## **Attachment A – TA-Air detailed comments on Air Quality Impact Assessment**

TA-Air has reviewed the AQIA *Air Quality Impact Assessment, 57 Tattersall Road, Kings Park, Todoroski Air Sciences Pty Ltd., November 2019*. The AQIA was generally prepared in accordance with the *Approved Methods for the Modelling and Assessment of Air Pollutants in NSW (Approved Methods)*. However, the following should be addressed before conditions of approval can be recommended:

Figure 2-1: Project location

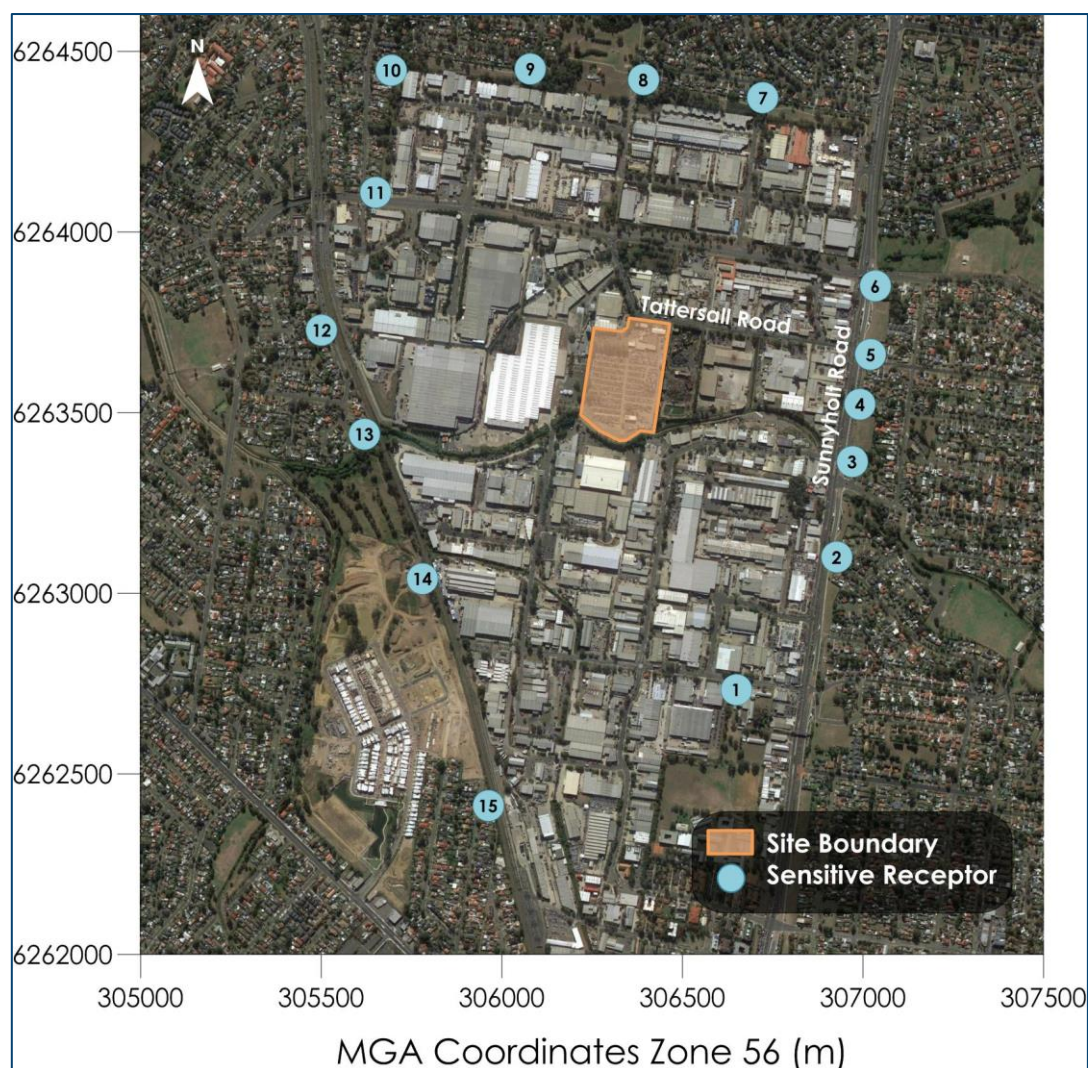
Modelling results presented in the assessment show predicted impacts of the project operations at 15 different receptors outside the industrial park. However, no receptors in the vicinity of the premises have been included as part of the assessment. Considering, there is a temple located less than 100m south of the project boundary and there is an ongoing history of complaints regarding odour, smoke and dust emissions primarily from adjacent industrial receptors, the inclusion of these receptors will help to better understand the potential impacts of the proposed operations. Further, the Approved Methods defines a sensitive receptor as a location where people are likely to work or reside.

- a) The AQIA is revised to assess the potential impacts of the proposed operations at various locations in the vicinity of the premises. This includes but is not limited to the temple located south of the project boundary and adjacent industrial receptors.***
- b) The AQIA is revised to include isopleth figures for all assessed pollutants that show predicted contour level concentrations at the adjacent industrial receptors. In addition, where possible these contour levels must include the contour level representing the appropriate criteria (e.g. odour).***

Figure 6-7: Predicted 99th percentile nose-response average ground level odour concentrations (OU)

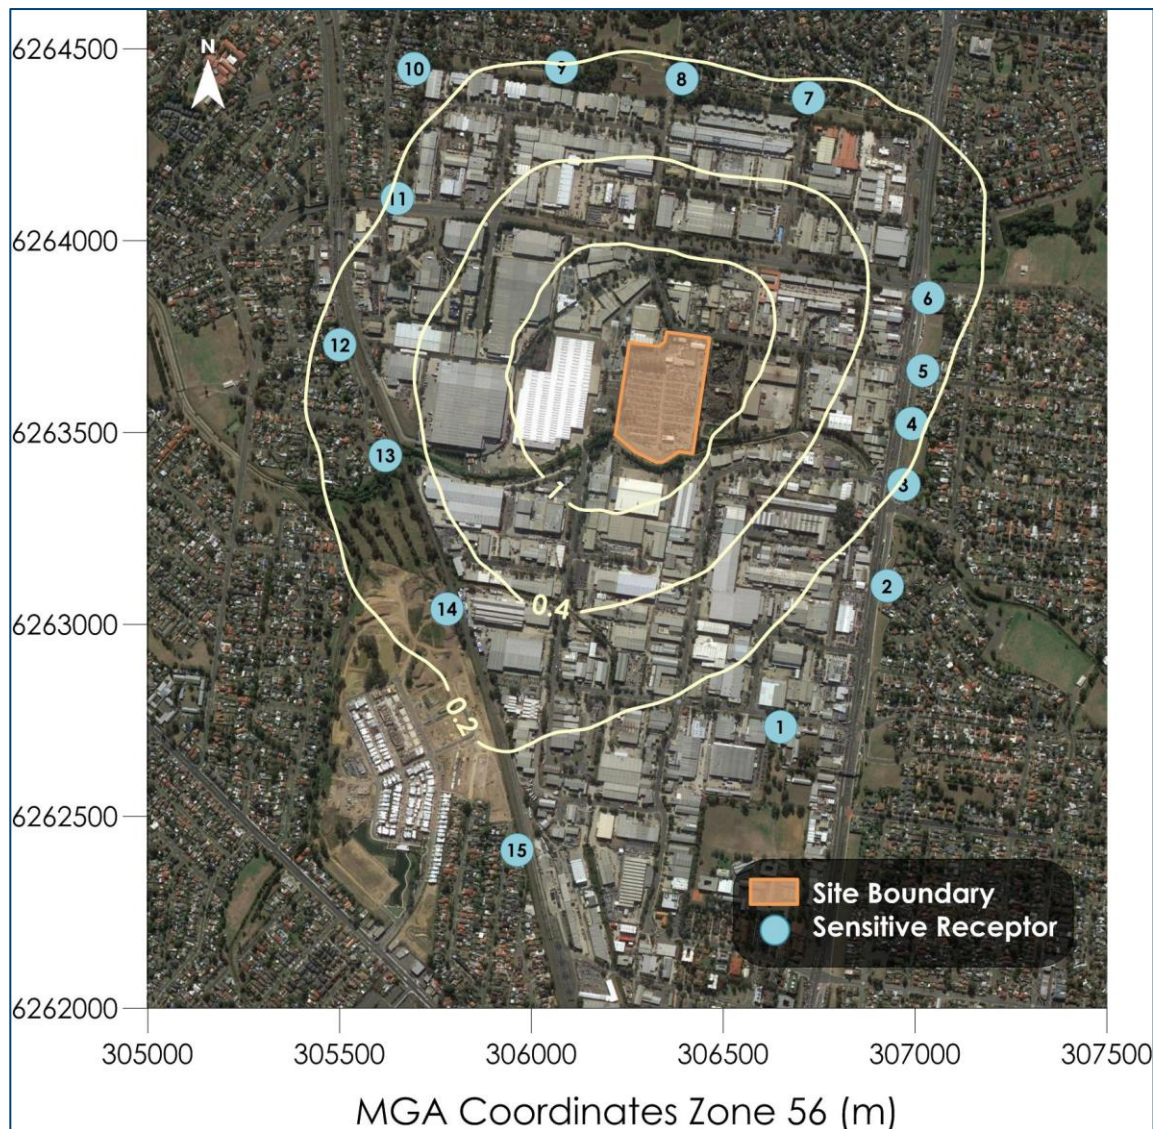
- The selected odour criteria for the assessment of odour concentrations is 2 OU. Although, there are not predicted exceedances at the selected receptors, the AQIA has not assessed potential impacts in the vicinity of the premises. It is noted, that the odour contour plot included in section 6.2 does not show the contour level representing the adopted criteria.

- a) **Assess all potential point and fugitive odour emission sources.**
- b) **Transparently justify assumed and adopted input variables used to calculate assessed emissions, including the applicability of the assumed odour concentrations to fugitive emissions and the velocity of 0.5 m/s.**
- c) **Include the 2 OU criteria contour in the odour contour plot in section 6.2.**
